The Drovers Solar Farm

Appendix 12.1: Consultation and Legislation, Planning Policy and Guidance (Clean)

Document reference: APP/6.4.1 (Revision 1)

DRAWING TITLE:
ES Figure 12.2 Indicative Watercourse Crossing

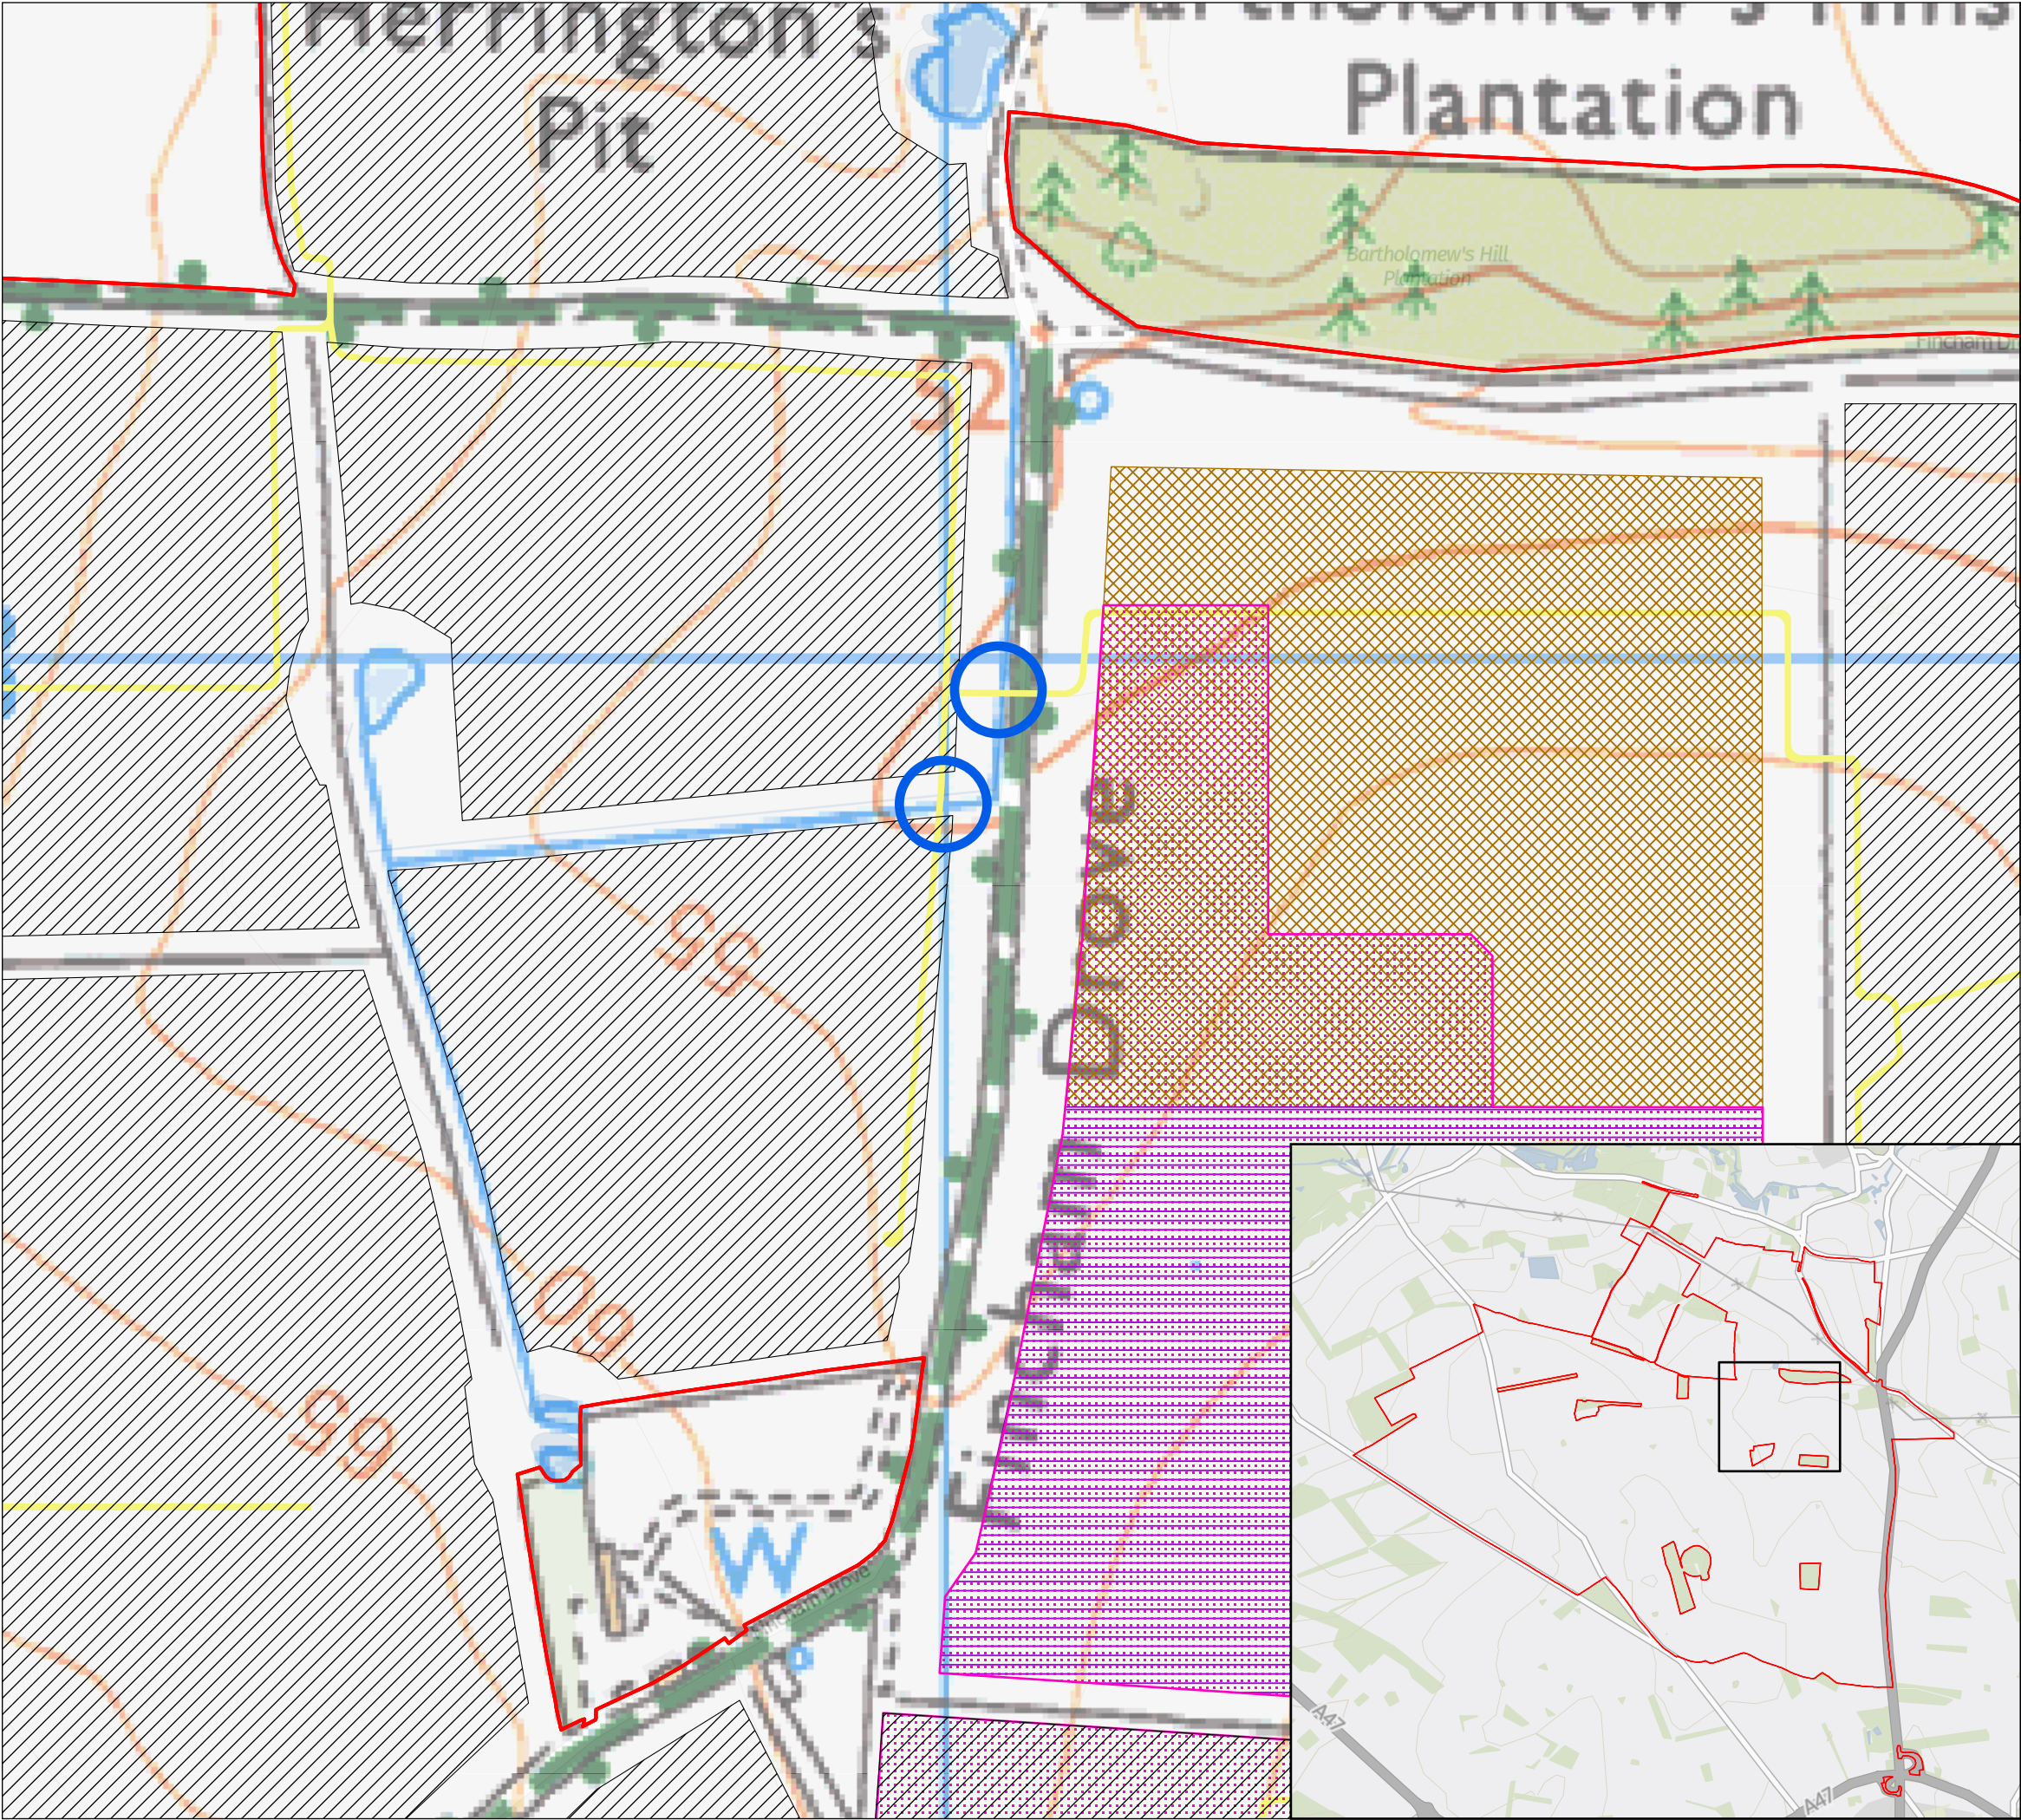
reminds the applicant that compacted material is considered impermeable and sustainable surface water management will be required for these temporary compound areas and new or improved temporary and permanent access track.		
	As this development covers a large area, a phasing plan supported by a construction phase surface water drainage plan will also be required to demonstrate there is no increase in flood risk in the construction phase (further information is provided in the LLFA's Developer Guidance). Otherwise, the proposed development could be considered not in accordance with the principles of NPPF and sustainable drainage.	A phasing plan will be provided as part of the detailed design of the Scheme following granting of the DCO, once a construction contractor has been appointed.	N/A
	Please note, if there are any works proposed as part of this application that are likely to affect flows in a river or watercourse, then the applicant is likely to need the approval of either Norfolk County Council, the Environment Agency or the local Internal Drainage Board. In line with good practice, these organisations seek to avoid culverting where possible. For Norfolk County Council, the consent for such works will not normally be granted except	Regarding watercourse crossings, the design of the Scheme does not have sufficient detail to confirm the exact locations of crossings at this stage. However, it is anticipated that the Scheme will require two crossings of a 'blind' / dead end ditch, which is not classed as an Ordinary Watercourse or Main River and which falls outside of the EA or LLFA remit for approval or issuing of consent. In any event, the draft DCO [APP/3.1] contains protective provisions for the benefit of the EA and drainage authorities.	Figure 12-2 of ES Chapter 12: Water Resources [APP/6.2] .

as a means of access. It should be noted that this approval is separate from planning.	The crossing locations are shown on Figure 12-2.	
	The LLFA notes the requirement for construction compounds however, there is no indication of the approximate location and number of them to support the development of the proposed site. Furthermore, the LLFA notes that as the site is to have a lifespan of 60 years, yet the design life of the PV panels is approximately 25-40 years and the batteries are 15 to 20 years, these structures are likely to be replaced at least once but more likely twice during the scheme's lifetime. The LLFA queries whether the permanent maintenance compounds to facilitate these maintenance activities will be provided with an associated impermeable area. The LLFA will require clarification on the location, duration and the surface water drainage arrangements for each of these construction compounds is requested to be included in the submission.	Maintenance compounds are not required for the operational phase of the Scheme. The oCEMP [APP/7.6] outlines how SuDS will serve Temporary Construction Compounds.	See section 3.8 of the oCEMP [APP/7.6] , which is secured via requirement of the Development Consent Order (DCO) Application.
